Our ref: DOC21/912839-2

Your ref: SSD-5144 MOD 10

Mandalong Southern Extension Project (SSD-5144 MOD 10) – Review of Modification Report

Mandalong Southern Extension Project (SSD-5144 MOD 10) – Review of Modification Report

Figure 6 | Habitat features and PCTs above LW34

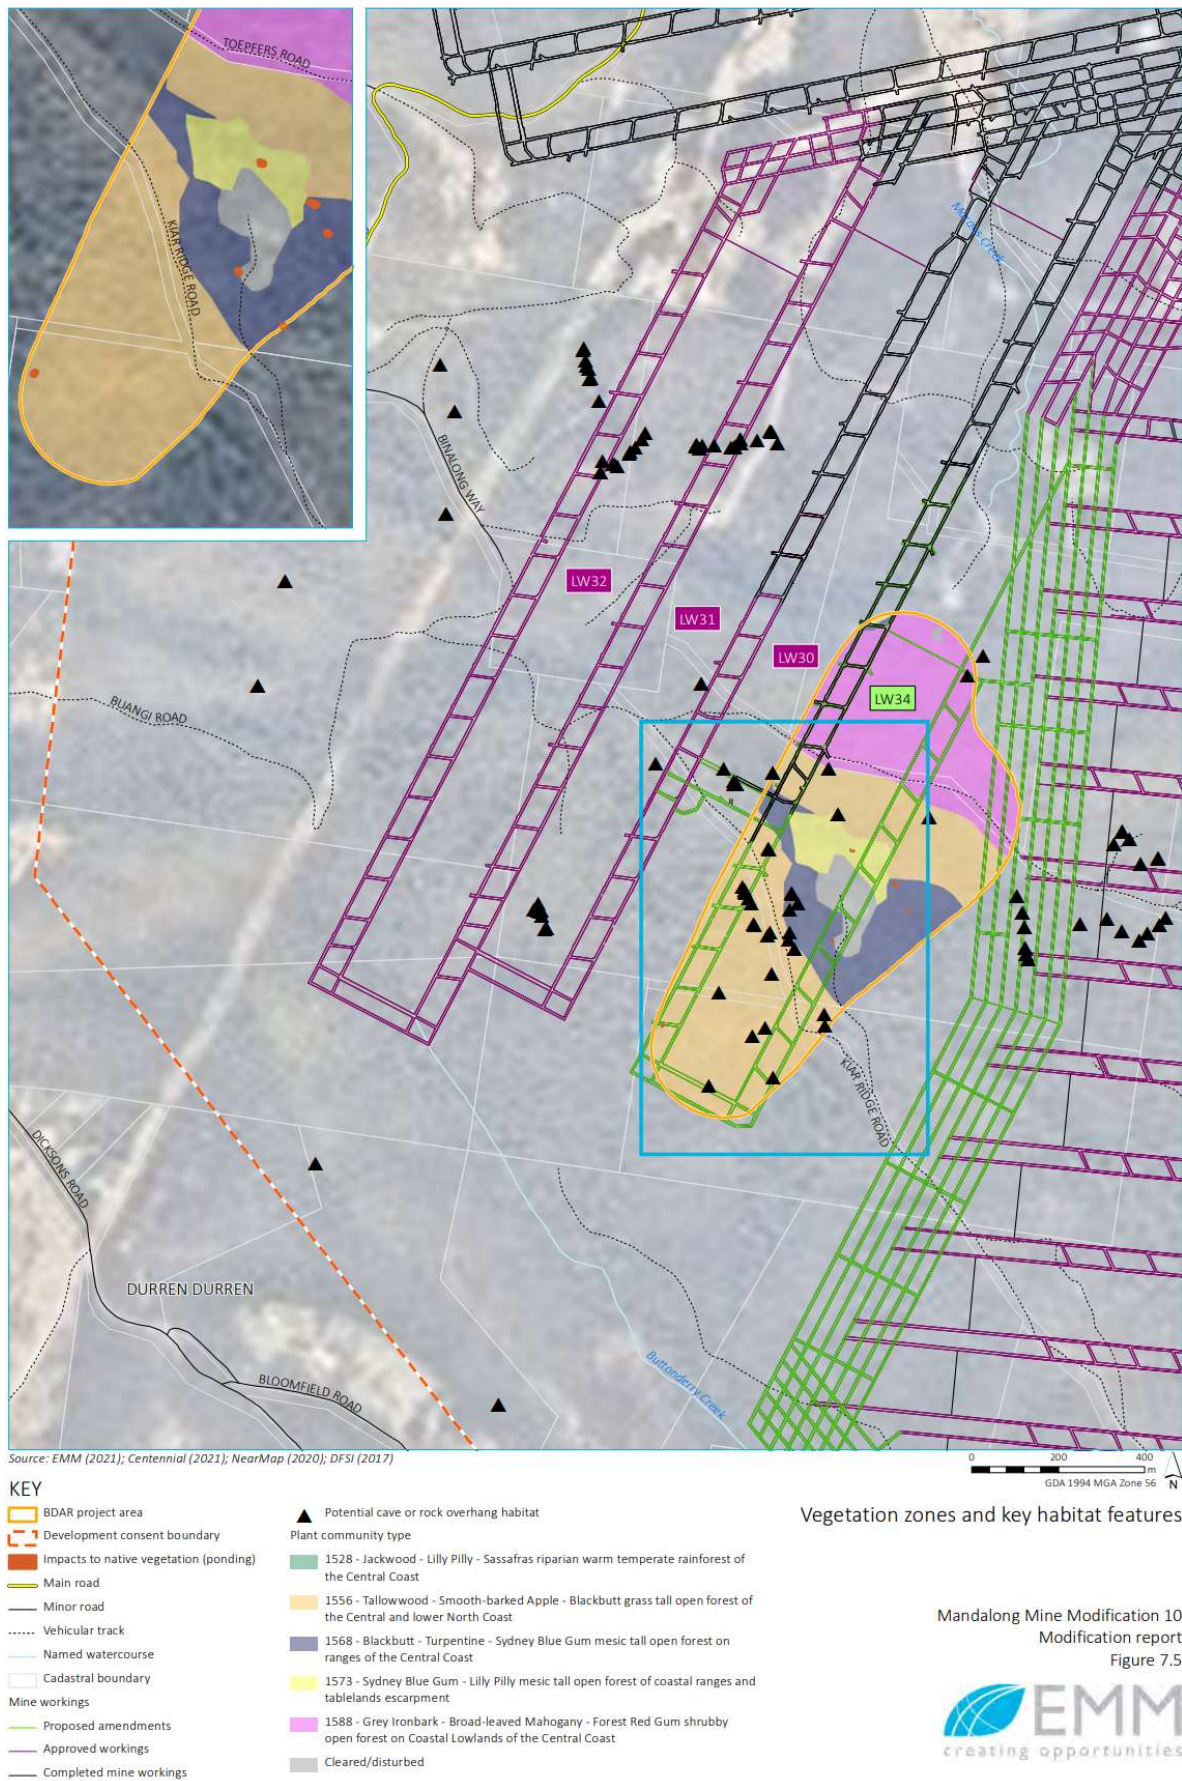
1. Consider ponding of native vegetation will result in total clearing and reassess in the BAM calculator

Section 6.1.1. 'Future vegetation integrity scores' in the Biodiversity Development Assessment Report (BDAR) allocates a partial loss, rather than a full loss, of the vegetation integrity score for native vegetation likely to be impacted by ponding from this project. BCD notes that the approach undertaken is based on the results of annual monitoring of vegetation above longwall panels elsewhere on the Mandalong South Coal Mine site. Section 8.1.1.2 of the Biodiversity Assessment Method (BAM) 2020 allows the future value of each component of the vegetation integrity score to be amended to reflect partial clearing. However, if such vegetation is likely to continue to degrade then the full loss of the vegetation should be assumed. It has yet to be demonstrated that full loss of vegetation will not occur over the 20 year timeframe that a BAM assessment considers, therefore BCD recommends that the precautionary principle is applied and that the nominal 0.01 hectares of vegetation considered to be directly impacted (Table 6-1 'Impacts to native vegetation') in the BDAR is considered to be fully cleared, and that the BAM Calculator (BAM-C) is rerun with the future vegetation integrity scores set to zero. This will require the BAM-C to be edited and the calculation re-run.

Section 3.2.4 'Targeted Flora Surveys' in the Biodiversity Inventory Report (BIR), which is Appendix A to the BDAR, does not demonstrate how the targeted flora survey undertaken meets BCD's targeted flora survey guideline ('Surveying threatened plants and their habitats: NSW survey guide for the Biodiversity Assessment Method' (DPIE, 2020)). BCD therefore recommends that the proponent provide more information on survey effort undertaken for threatened plant species, including:

- c. A revised copy of Figure 3-1 'Targeted Flora Searches' that shows targeted survey effort in relation to each threatened plant species. Where more than one threatened species shares exactly the same area of suitable habitat then those species may be shown on the same map.

Section 3.3 'Fauna Surveys' in the BIR does not demonstrate how the targeted fauna surveys undertaken meet BCD's targeted fauna survey guidelines, and where appropriate, relevant Commonwealth Government survey guidelines. BCD therefore recommend that the proponent provide more information on survey effort undertaken for threatened animal species, including:

- x. Whether the survey guidelines have been met for each species.
- b. A revised copy of Figure 3-2 'Fauna Survey Effort' that shows targeted survey effort in relation to each threatened fauna species. Where more than one threatened species shares exactly the same area of suitable habitat then those species may be shown on the same map.

Section 4.2.1 'Plant Community Types (PCTs)' in the BIR does not discuss how on-ground vegetation was matched to a PCT, nor the degree of confidence of the match. BCD recommends that a summary of process by which on-ground vegetation was matched to a PCT based on key species, geographic location, landscape position and other relevant physical attributes (such as substrate). Include the short-list of the top two to five options, the reason for the final match, and the degree of confidence in the final match.

BCD recommends that nominal area of native vegetation likely to be affected by ponding following longwall mining is considered to be fully cleared and treated as such in the Biodiversity Assessment Method Calculator.

BCD recommends that further information is provided to show how targeted flora surveys met 'Surveying threatened plants and their habitats: NSW survey guide for the Biodiversity Assessment Method' (DPIE, 2020).

BCD recommends that further information is provided to show how targeted fauna surveys met BCD's survey guidelines.

BCD recommends that further information is provided to show how on-ground vegetation was matched to a Plant Community Type, and the degree of confidence in the match.
